RE: LOT11A, BLOCK 13, FOUR HILLS VILLAGE 7TH INSTALLMENT (M-23/D-14)
GRADING RESUBMITTAL FOR FINAL PLAT APPROVAL. ENGINEER'S STAMP
DATED 4-22-99

RE: LOT 11A, BLOCK 13, FOUR HILLS VILLAGE 7TH INSTALLMENT (M-23/D14) GRADING
SUBMITTAL FOR FINAL PLAT & BUILDING PERMIT APPROVAL. ENGINEER'S
STAMP DATED 3-25-99.

EXISTING DRAINAGE
LOT 11A, BLOCK 13, FOUR HILLS VILLAGE 7TH INSTALL.

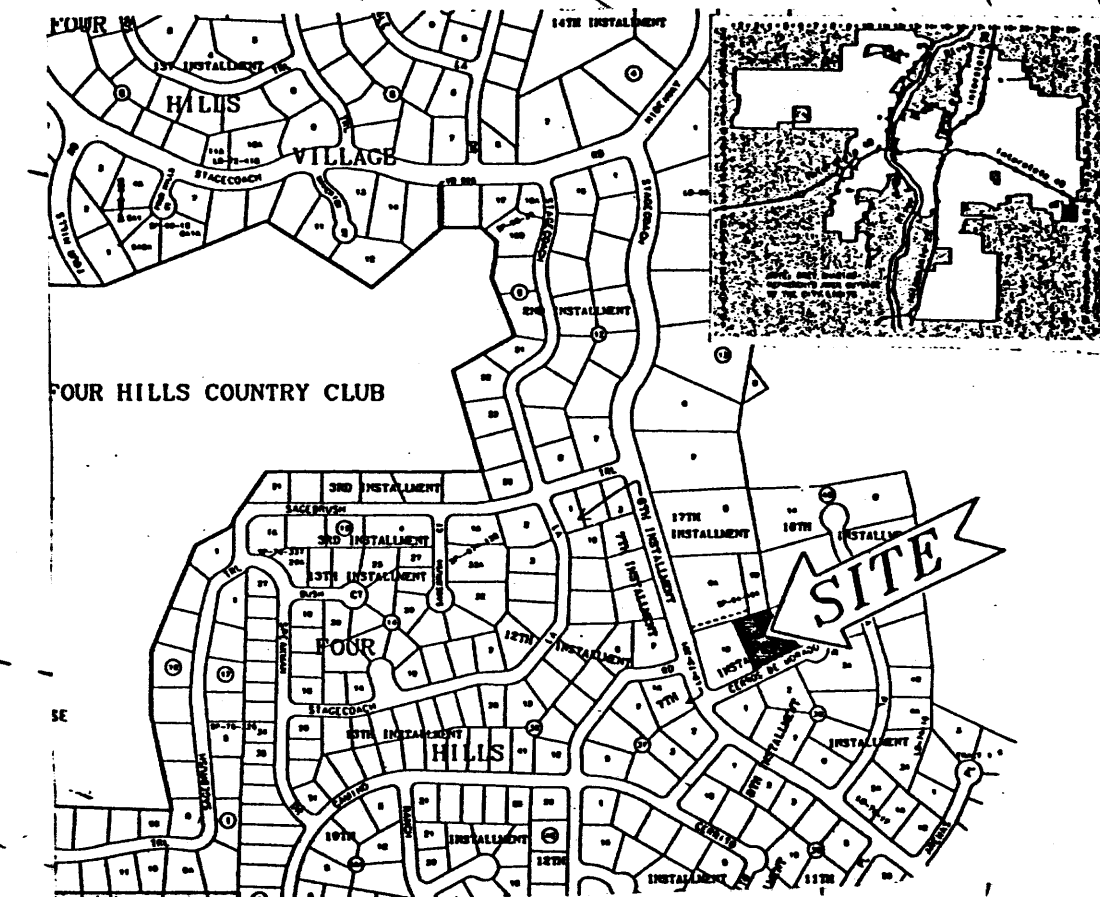
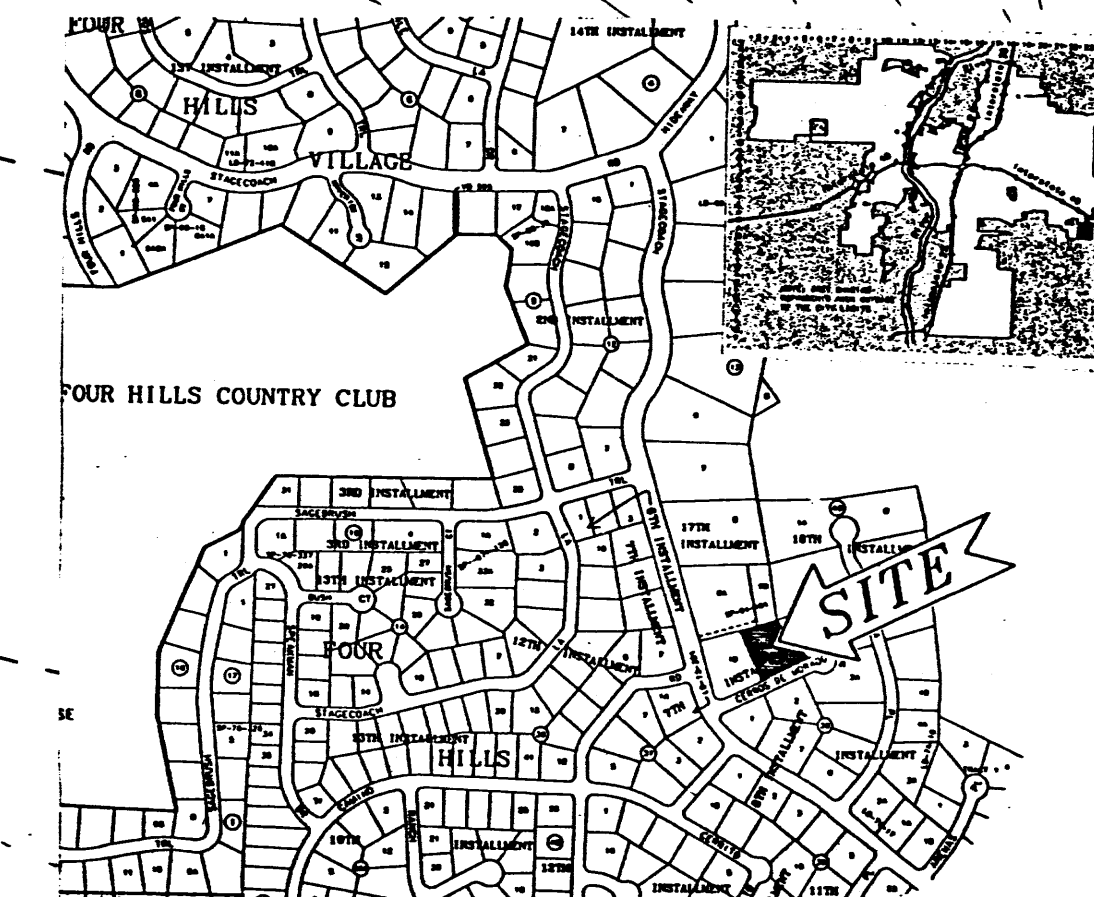
- The amount of floodwater impacting the referenced lot from upstream properties is negligible.
- No public waters from Cerros De Morado impact the subject property (Lot 11A)

If either of the listed statements are incorrect, please contact me. I have discussed these issues with Mr. Fred Aguirre from this office, and it is our opinion that there appears to be no need for the proposed drainage easement along the eastern lot line of this property. Given that, it appears that as a part of your current platting action you should simply ask to vacate the existing drainage easement, as you are currently proposing. In preparing your resubmittal, please include existing spot elevations on the curb & gutter along Cerros De Morado, adjacent to your site.

In obtaining a Building Permit for this project, I don't believe that it is necessary to first obtain City Hydrology approval of a drainage and grading plan. Given that, your resubmittal should be for Final Plat approval only (with vacation of drainage easement included).

The attached drawing confirms our discussion on the drainage pattern on and adjacent to the referenced property, specifically:

A. The amount of runoff onto the proposed lot 11A from upstream properties is negligible.

B. There is no runoff from public property, neither the Cerros De Morado street surface, nor the La Tuna street surface, which enters the lot 11A property. There are no other public properties which could drain onto lot 11A.

I request your approval for the vacation of the existing drainage easement along the east property line of the existing lot 11 in order that lot 11A can be platted without the interior easement.
